**APPROVED**  
Limited building only review  
Permit holder responsible for full compliance with the code

06/07/2022

PROJECT:  
3 BR SFD

CLIENT: ROBERT WIGGINS  
PROJECT: NEW SFD  
LOCATION: BROADWAY NC

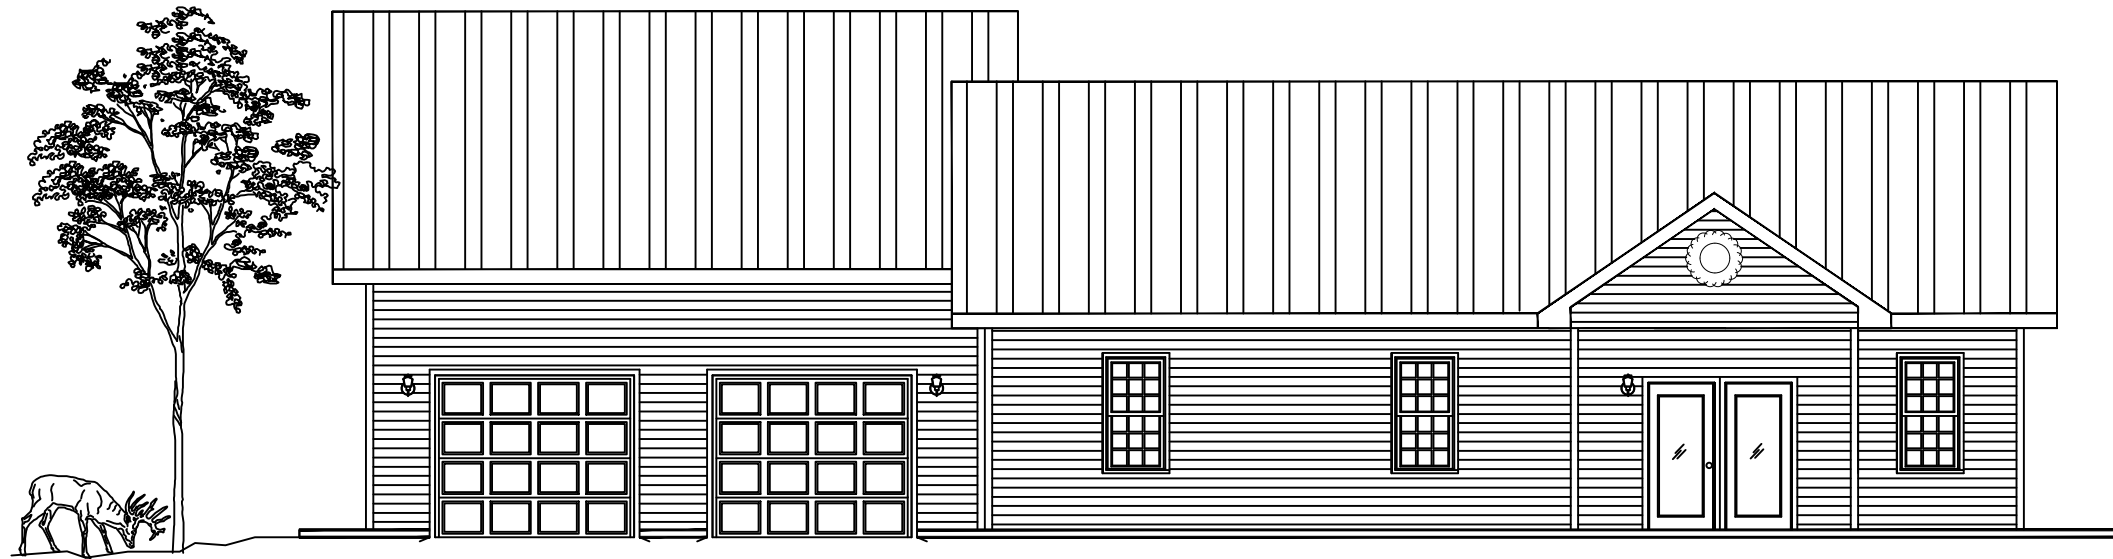
This area may not be enclosed beyond screening due to egress route

System for garage must be a completely separate system from the house.

This wall and all doors must fire rated per NCRC2018

GARAGE ENTRY SECTION
3/4" = 1'-0"

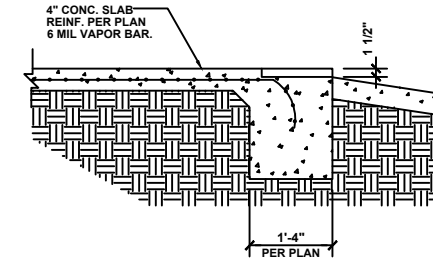
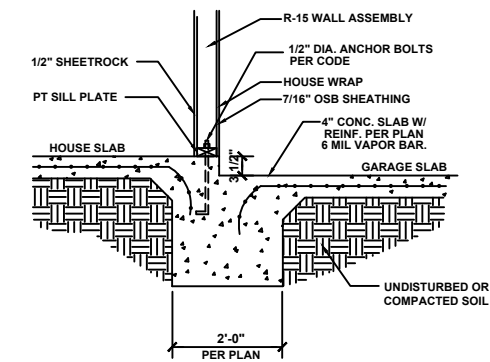
R-10 Slab insulation  
required
